DEVELOPMENT HEARING OFFICER

PR-2019-002668

SD-2024-00124 – PRELIMINARY/FINAL PLAT
IDO – 2024

REQUEST: Create Lot 28-A-1-A & 28-A-1-B to dedicate 28-A-1-B to AMAFCA in fee simple per agreement between owner and AMAFCA. Lot 28-A-1-B contains AMAFCA's existing concrete channel and facilities

PLAT FOR
 LOT 28-A-1-A & 28-A-1-B
 INTERSTATE INDUSTRIAL TRACT
 (A REPLAT OF LOT 28-A-1, INTERSTATE INDUSTRIAL TRACT)
 WITHIN THE
 ELENA GALLEGOS GRANT
 PROJECTED SECTION 23,
 TOWNSHIP 11 NORTH, RANGE 3 EAST, N.M.P.M.
 CITY OF ALBUQUERQUE
 BERNALILLO COUNTY, NEW MEXICO
 MARCH, 2024

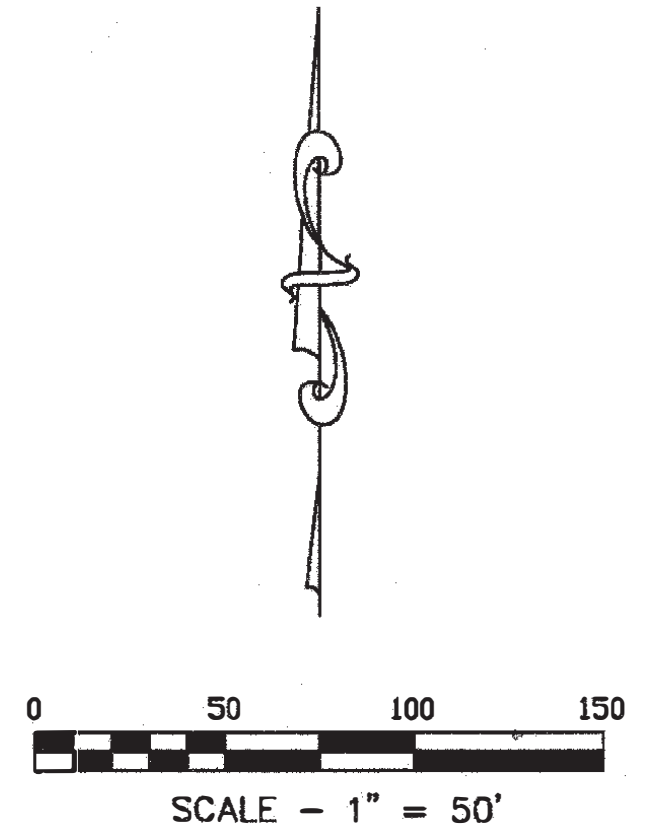
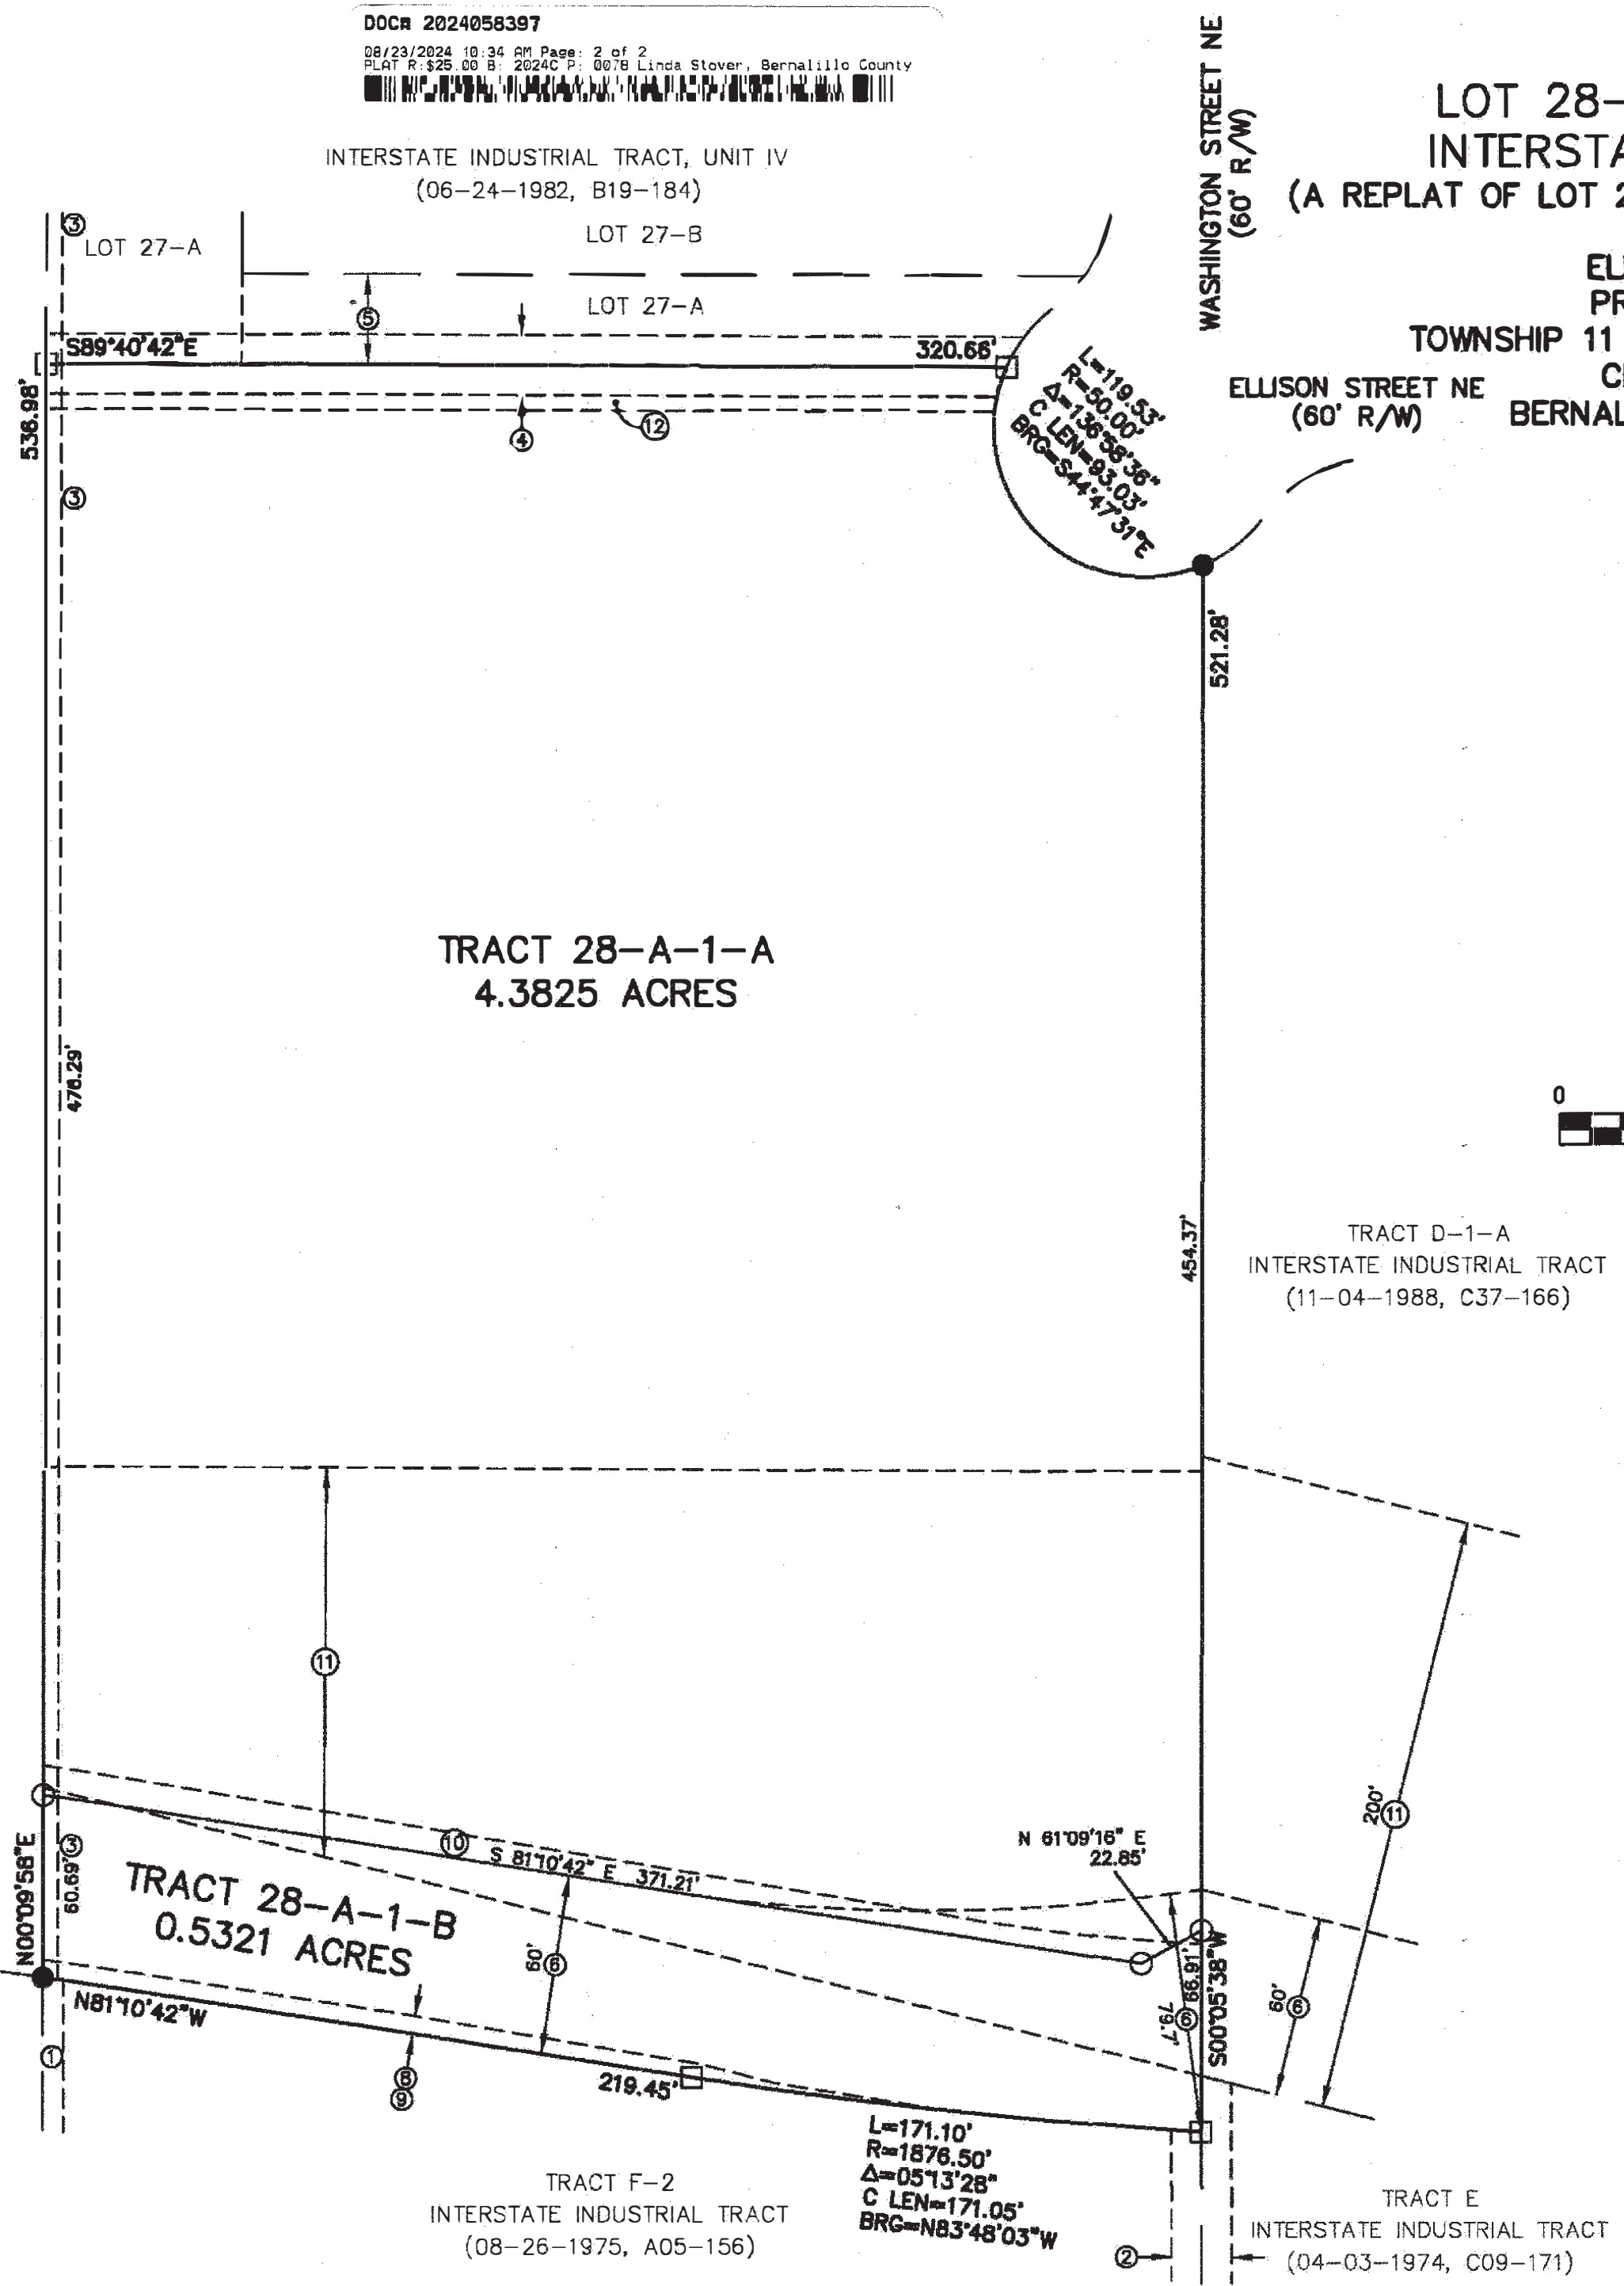
- **Confirm the details of the proposed Preliminary/Final plat for the DHO at the hearing.** Subdivision of land and dedication of ROW.

- Clarify and confirm if the easement in orange is still active and if it will affect this request.

- The Project and Application numbers must be added to the plat before final sign-off of the Plat.
- A copy of the AGIS-approved DXF file must be submitted prior to the final sign-off of the Plat.
- Per 6-6(L)(2)(d)(7) of the IDO, the date of the DHO approval shall be recorded on the Plat.
